MONA OFFSHORE WIND PROJECT

Mona Change Request Report

Document Reference: SCR

Document Number: MOCNSGS111

Extract from Change Request:
Works Plan - Onshore
(Document Reference
S_CR_4 F02)

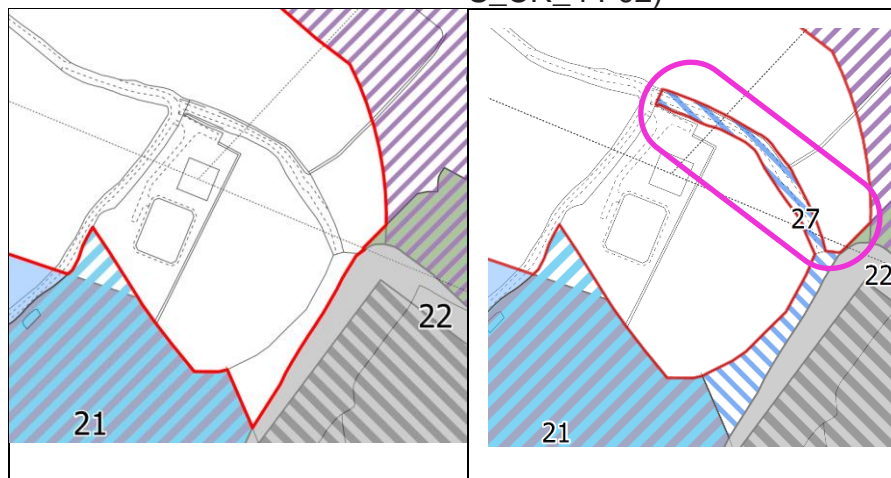
Change 1a – Order Limits change to include an existing access track to the west of the onshore substation for temporary access during onshore site preparation works

1.2.1.2 This change will result in the inclusion of a section of the existing access track at the onshore substation at grid reference SJ 01353 73277 within the Order Limits to accommodate temporary access.

1.2.1.3 This existing access track is currently being utilised by the Applicant for ongoing site survey and investigation works. This change does not involve any works or upgrades to the existing track, the track will only be used to take access to Work Nos. 21, 22 and 33 (and other works areas through Work Nos. 21, 22 and 33).

1.2.1.4 As shown on the Change Request: Works Plan - Onshore (Document Reference S_CR_4 F02), Change 1a will become part of Work No. 27.

Extract from Change Request: Works Plan - Onshore (Document Reference S_CR_4 F02)

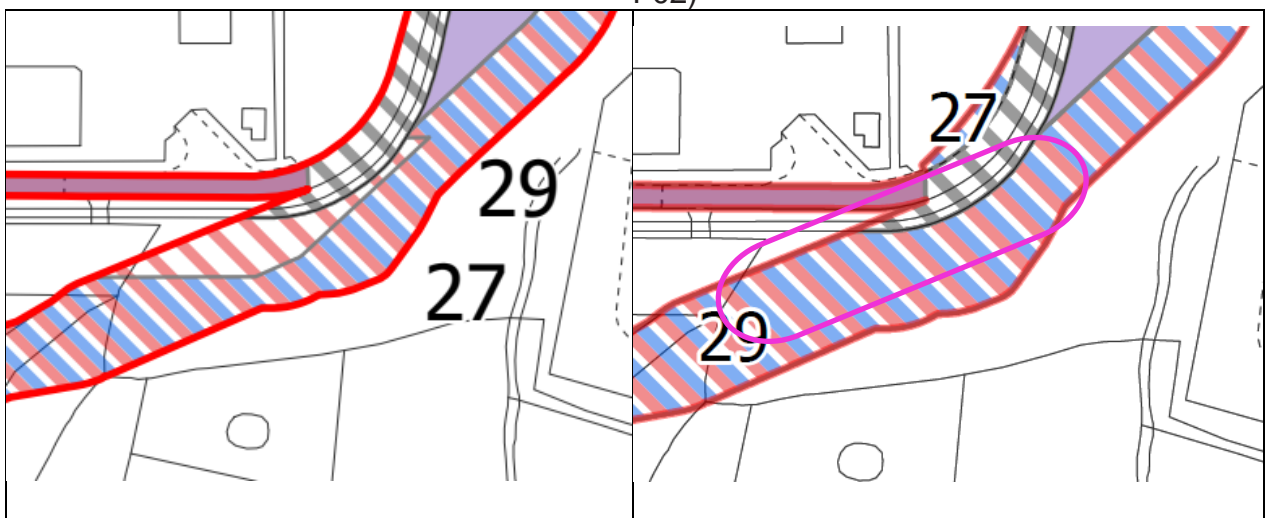
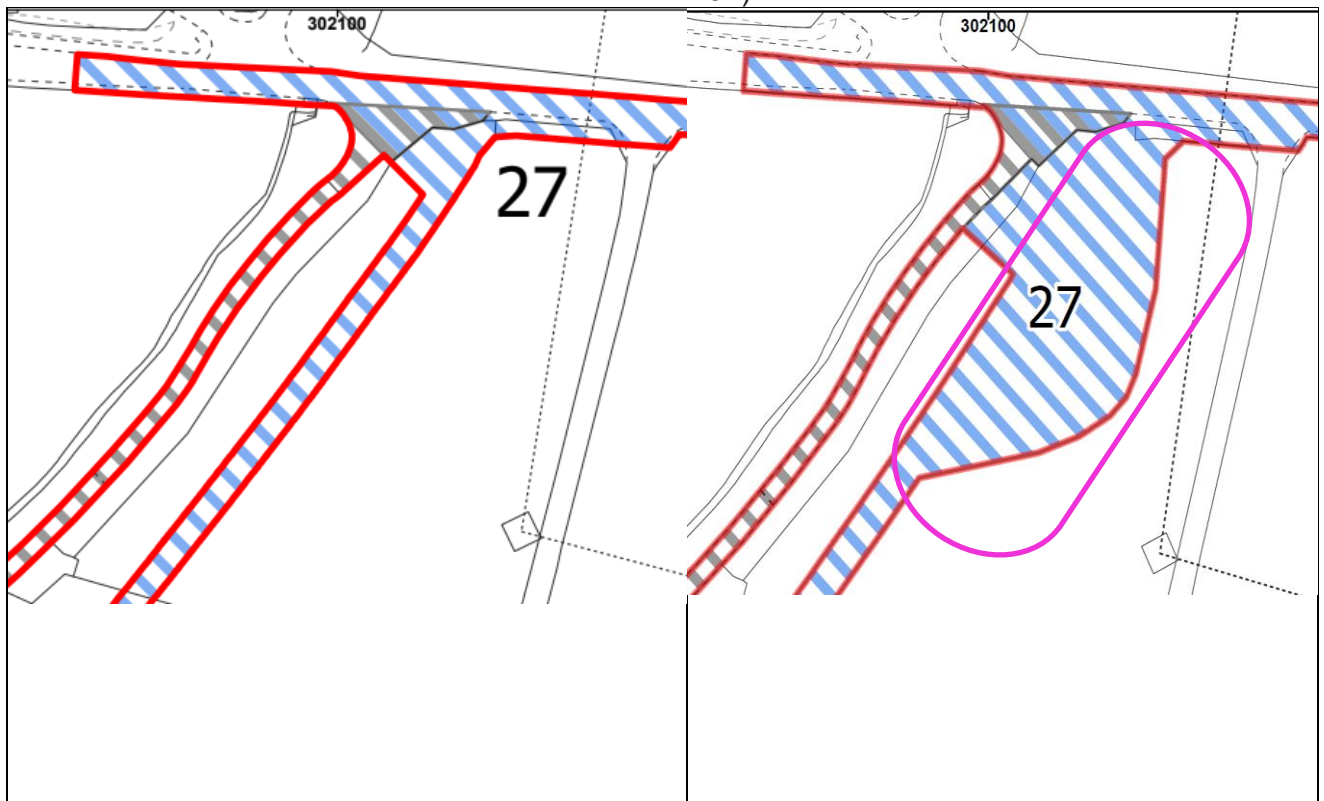
Change 00 – Amendment to Work No 000 to widen the temporary onshore substation construction access road at grid reference S 1000 00001 by including a small area of additional land to the area identified for Work No 000 (approximately 000m within the existing Order Limits. This land is currently identified as part of the permanent onshore substation access (Work No 0000 only.

- 1.2.2.4 The Applicant's preliminary design work has identified additional space is needed along the temporary construction access road in this area to facilitate the AIL's whilst ensuring adequate space for the fencing requirements outlined in the Outline Fencing Management Plan (REP2-048).

Extract from Works Plans – Onshore (AS-003) Extract from Change Request: Works Plan - Onshore (Document Reference S_CR_4 F02)

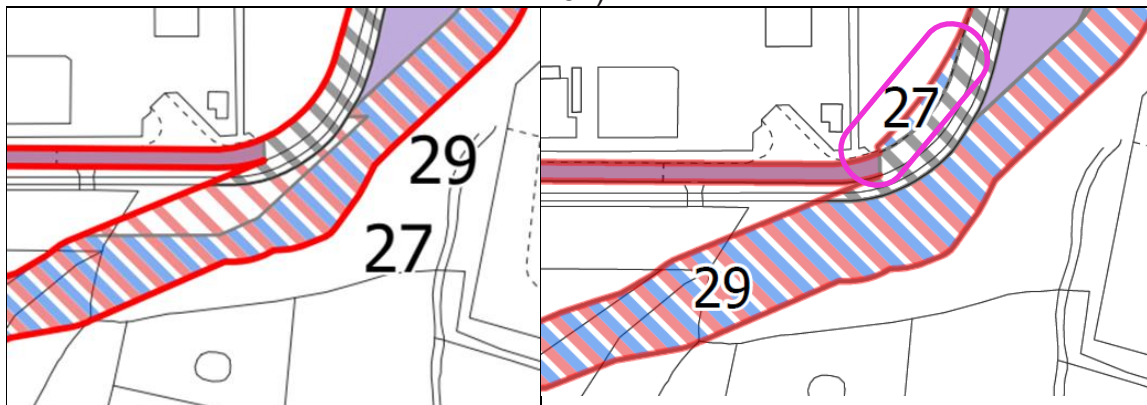
1 **Change – Amendment of the proposed Order Limits to include additional land adjacent to the onshore substation construction access ellmouth to accommodate a temporary construction drainage attenuation asin**

- 1.2.3.1 This change results in a widened temporary onshore substation construction access road (eastward) to accommodate an additional temporary Sustainable Urban Drainage System (SuDS) attenuation pond at the northern extent of the onshore substation construction access road.

- 1.2.3.2 The additional area of land required for Change 3 amounts to approximately 2350m². Whilst this land was included within the Mona PEIR Offshore Wind Project Boundary published in April 2023, it was not included upon submission on the basis of the preliminary designs for the onshore substation construction access road. However, the Applicant's early detailed design works for the onshore substation construction access road, including the swept path analysis outlined in Change 2 (specifically Change 2a), have identified the need for additional land take. This is in order to deliver attenuation to control the discharge of surface water during construction, in part due to the wider road outlined in Change 2a, and also from the requirement for great crested newt fencing to be deployed, likely resulting in additional drainage pathways. It is proposed to construct a temporary SuDS attenuation basin as a measure to control this additional surface water runoff. The proposed Change 3 will result in

a controlled surface water discharge into an existing drainage channel, reducing the risk of increased flooding downstream.
